Our Ref: CM/38/18/PL

4th January 2019

**Town & Country Planning Act 1990 (as amended)
Town and Country Planning (Development Management Procedure) (England) Order 2015
Application for Full Planning Permission**

Development Retention of 5 No. temporary storage containers for ancillary storage. This application affect the setting of listed buildings.
Location Clymping Mill Clymping Street Clymping

Site Plan: 1:500@A3

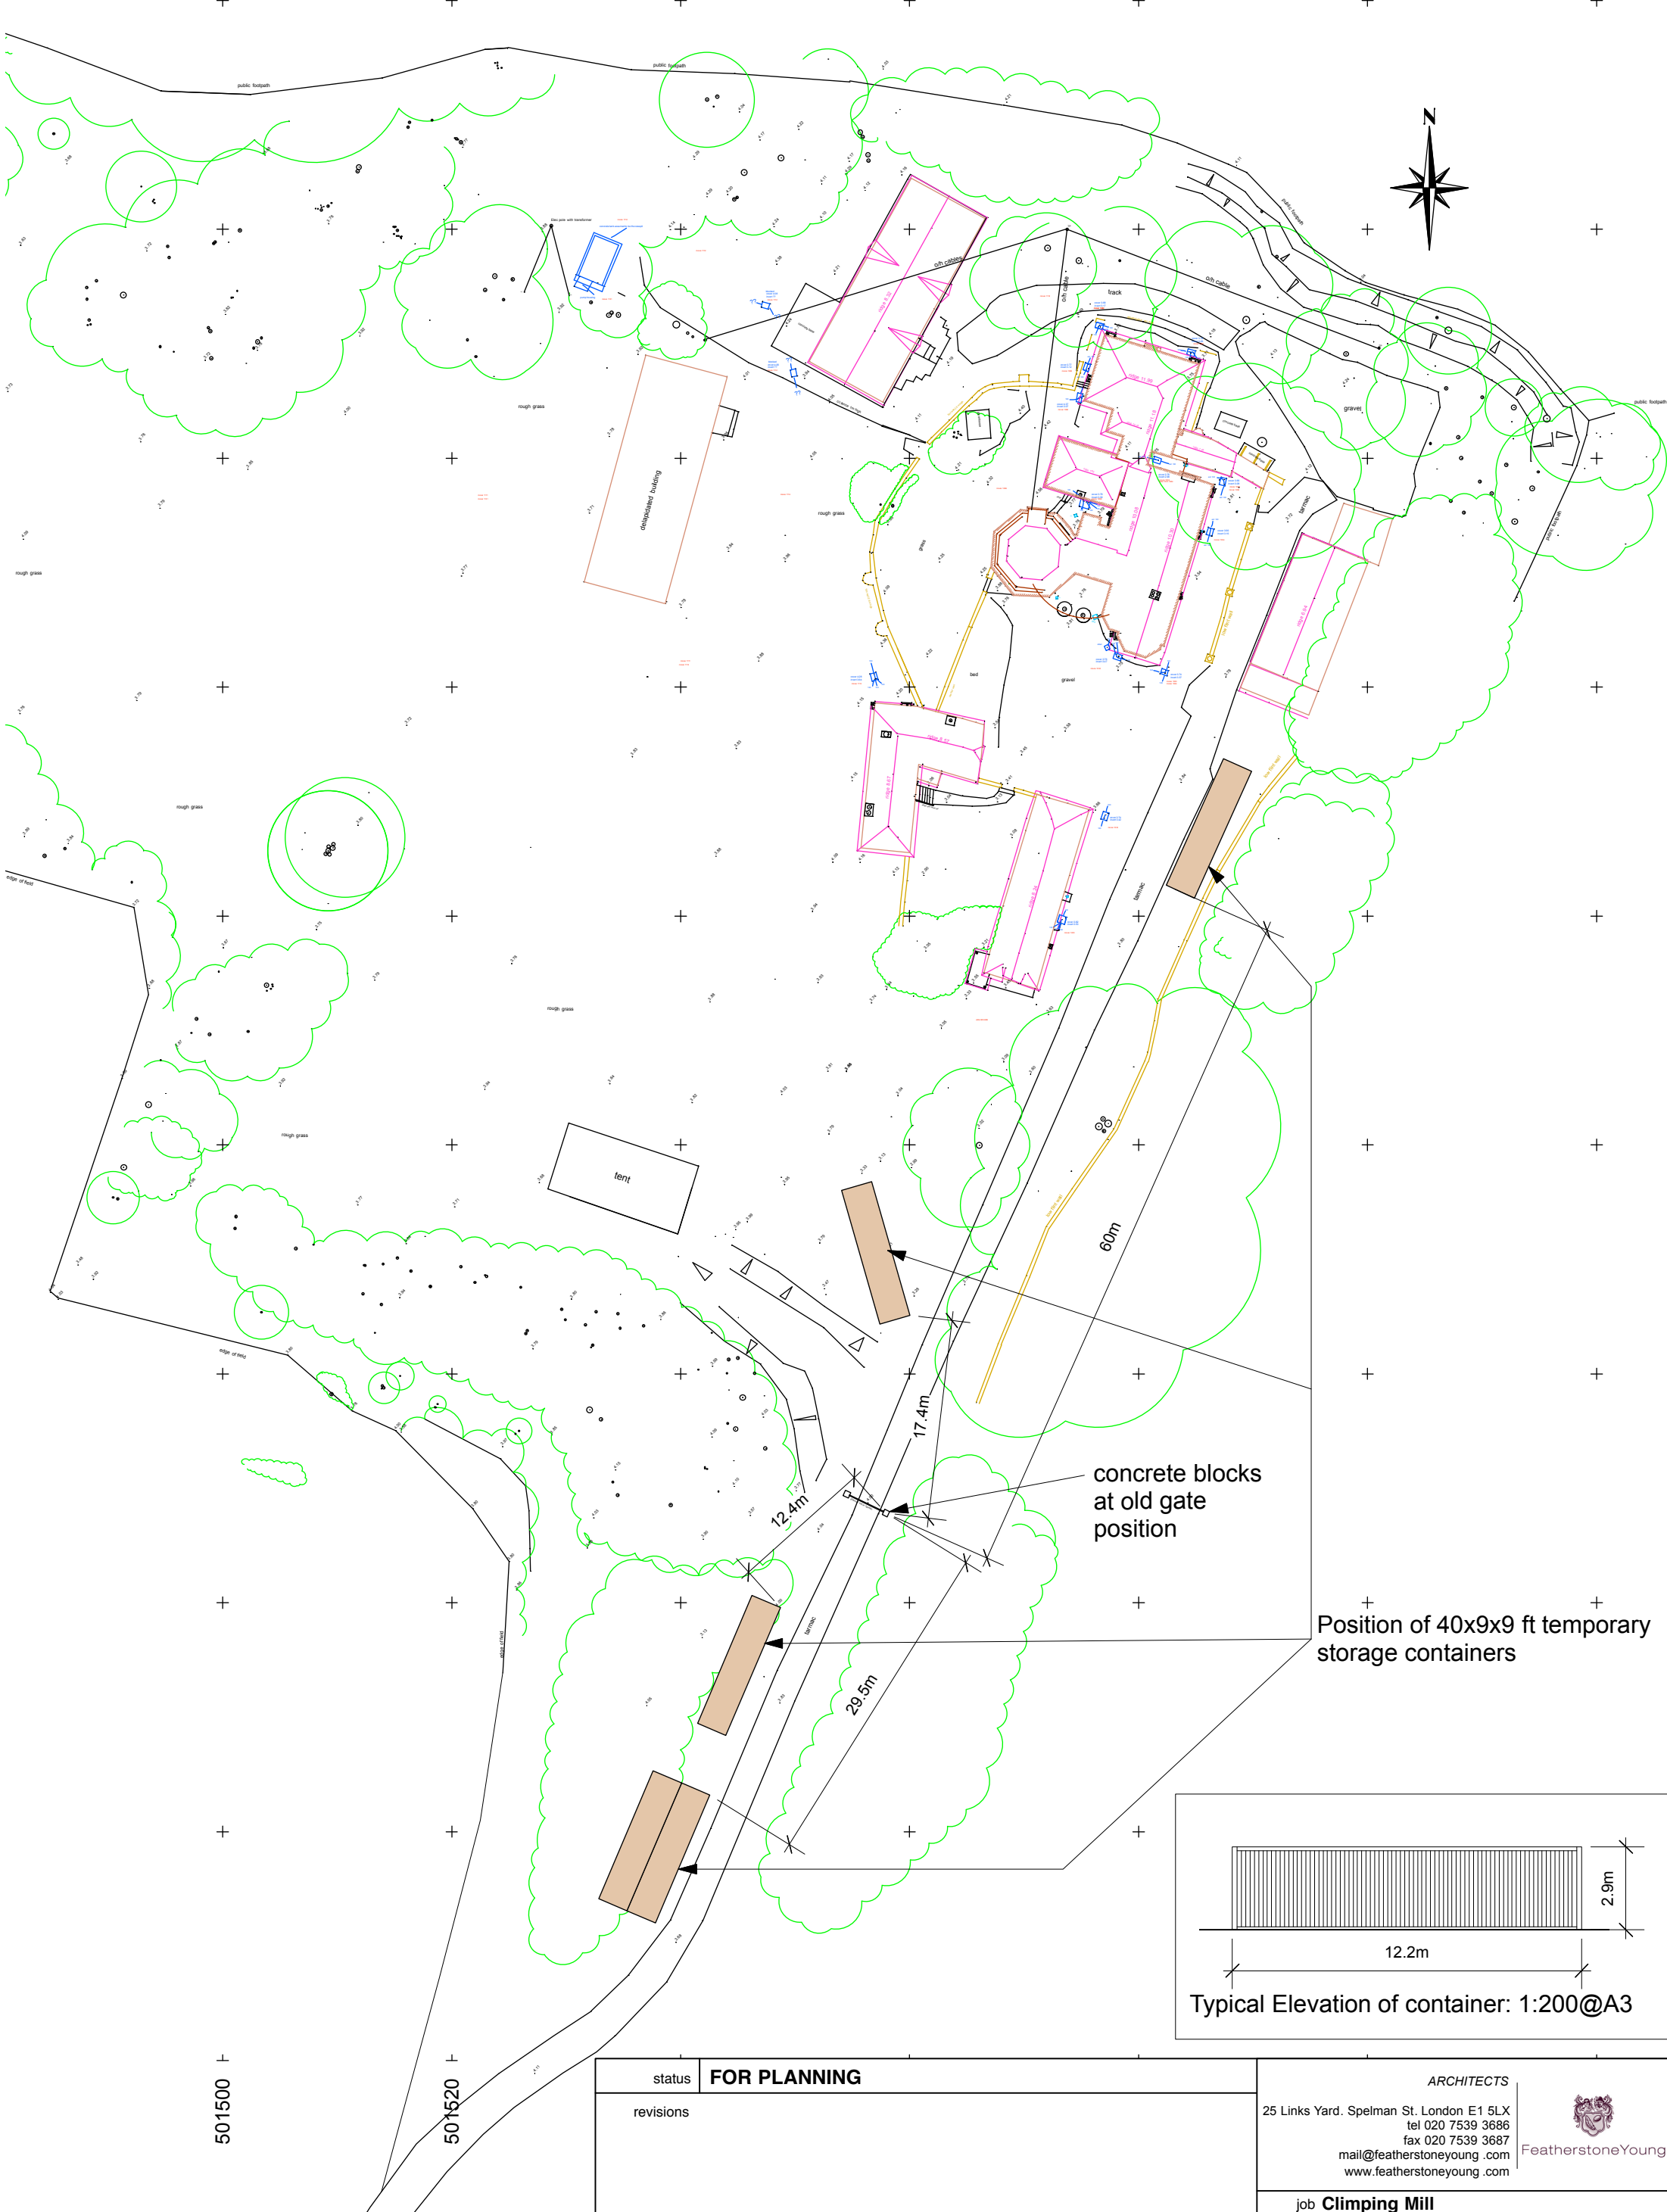
On the block plan, please show more of the site, to the south, to include the southern most boundary of the site to match the southern end on the location plan.

Location Plan: 1:2500@A3

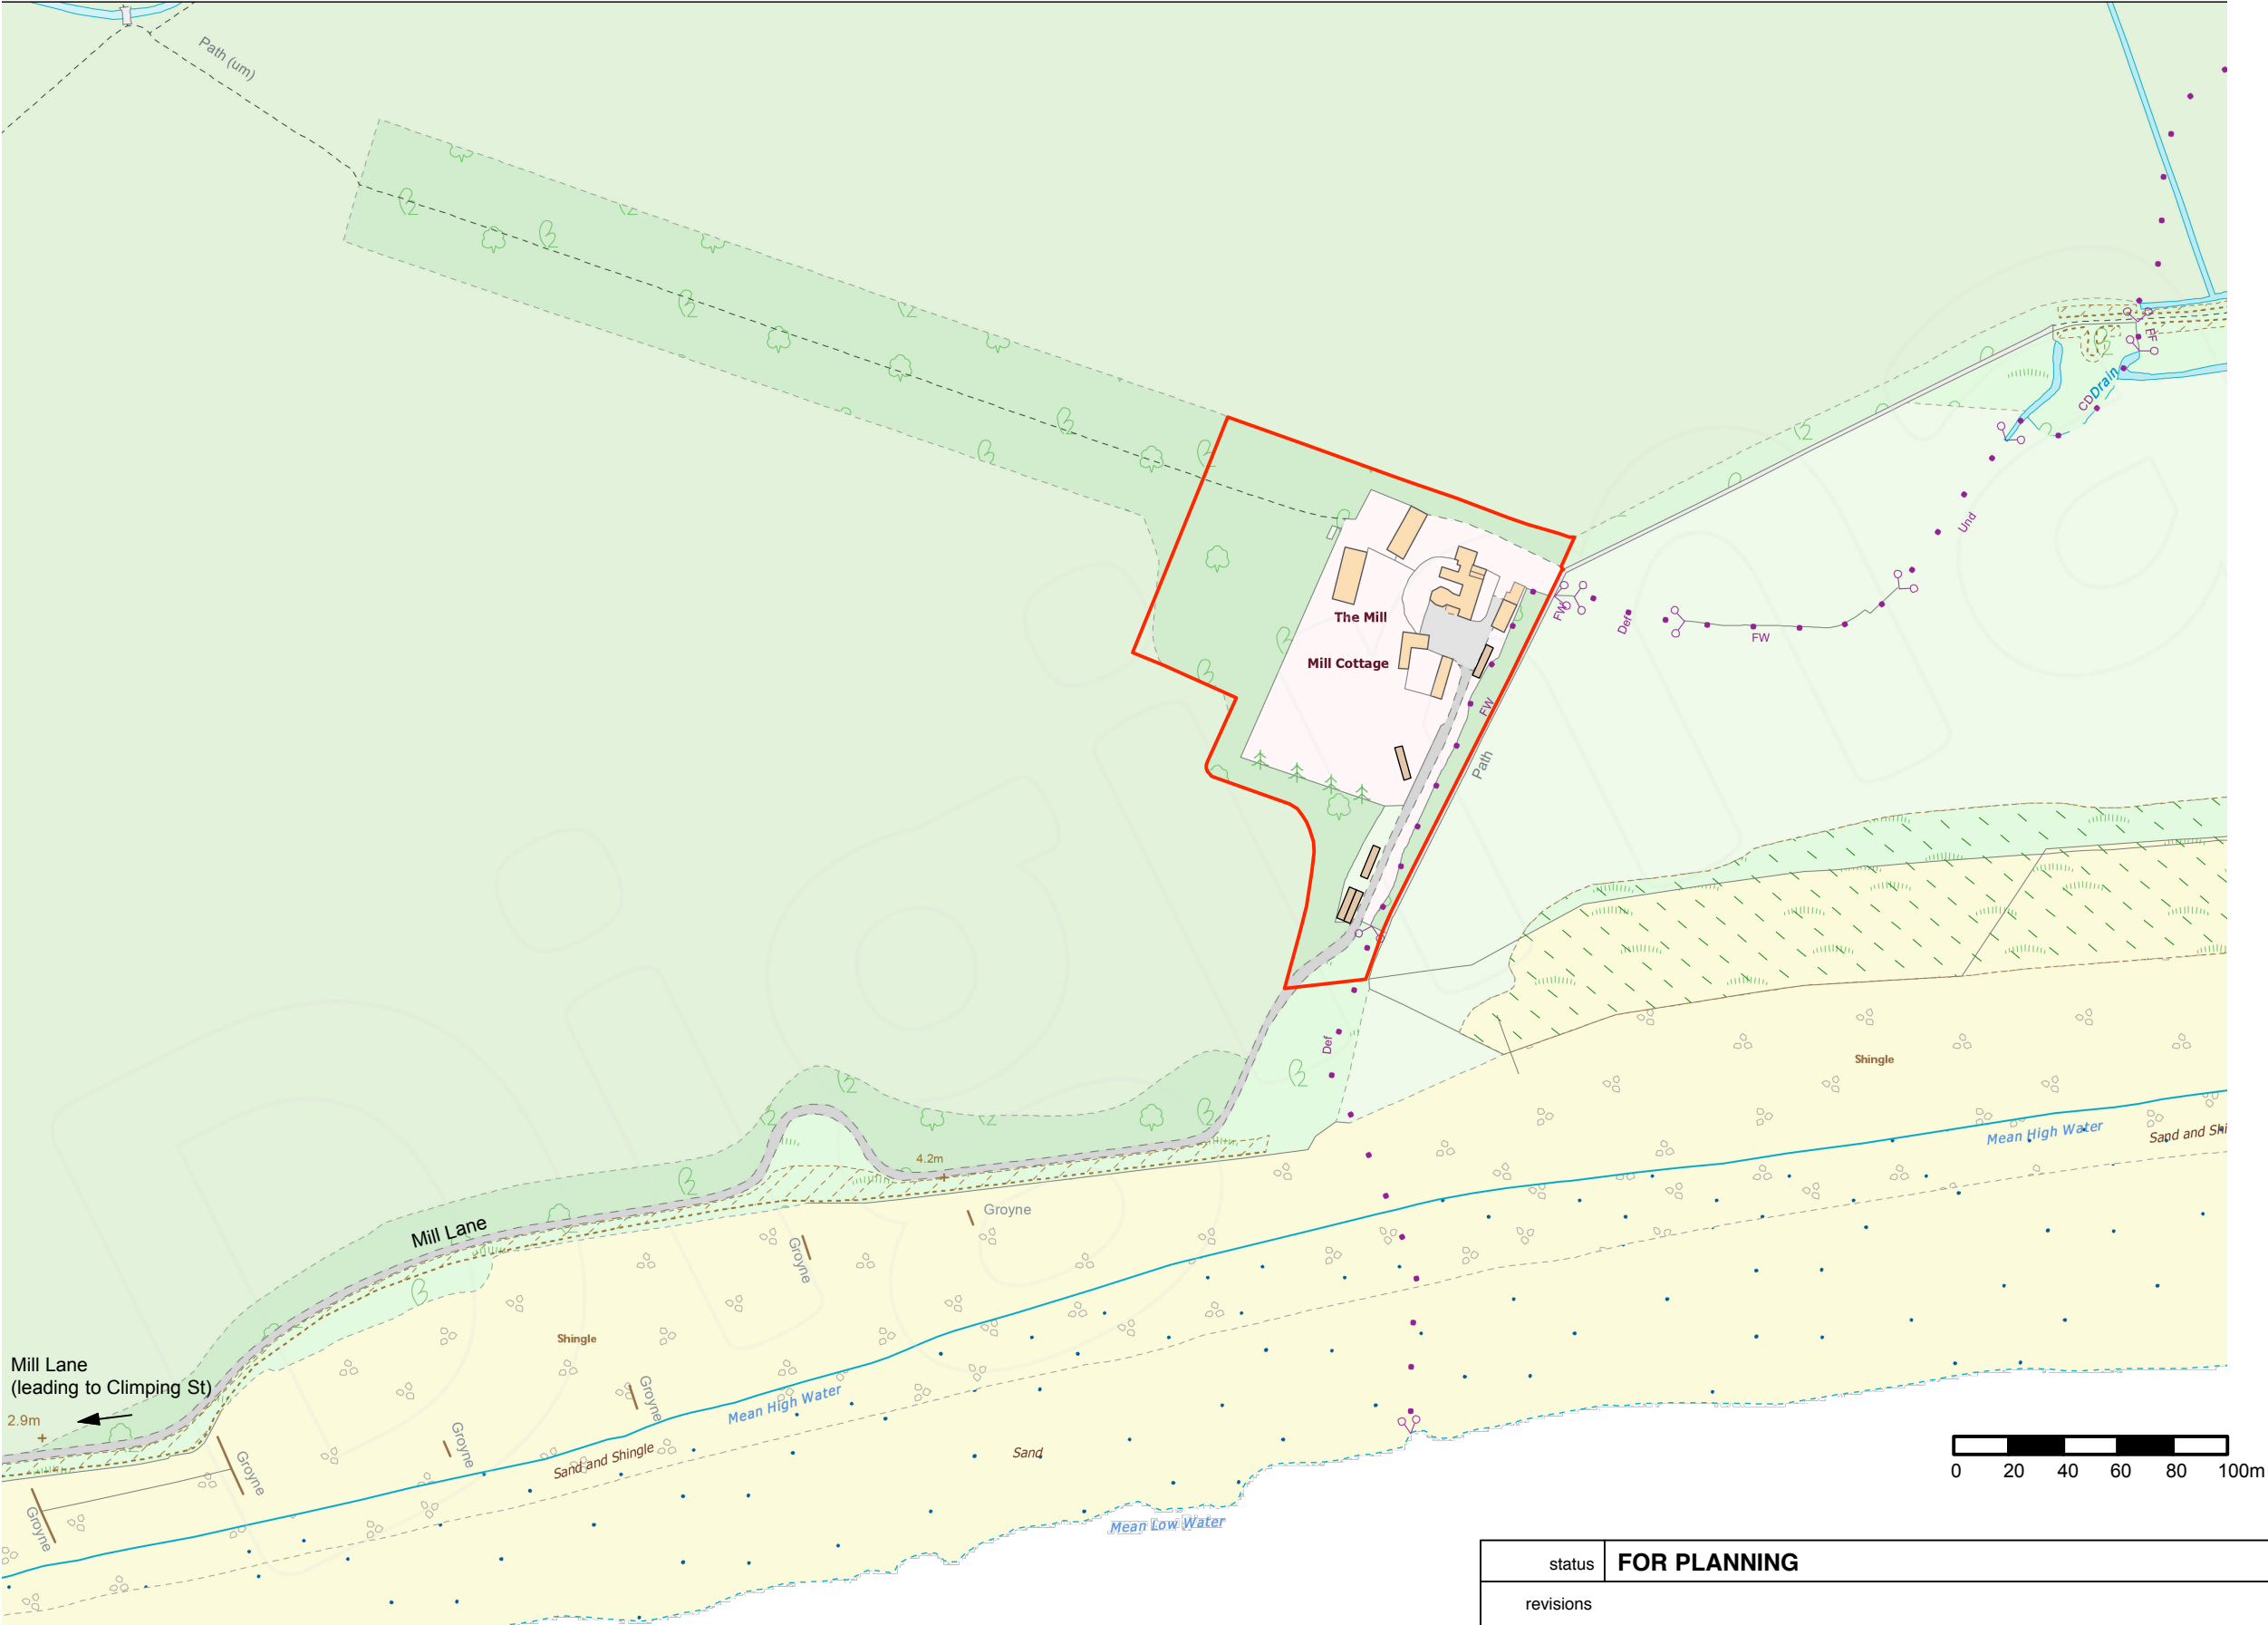
On the location plan, please show, to scale, in metres, the position of the 5 No. storage containers.
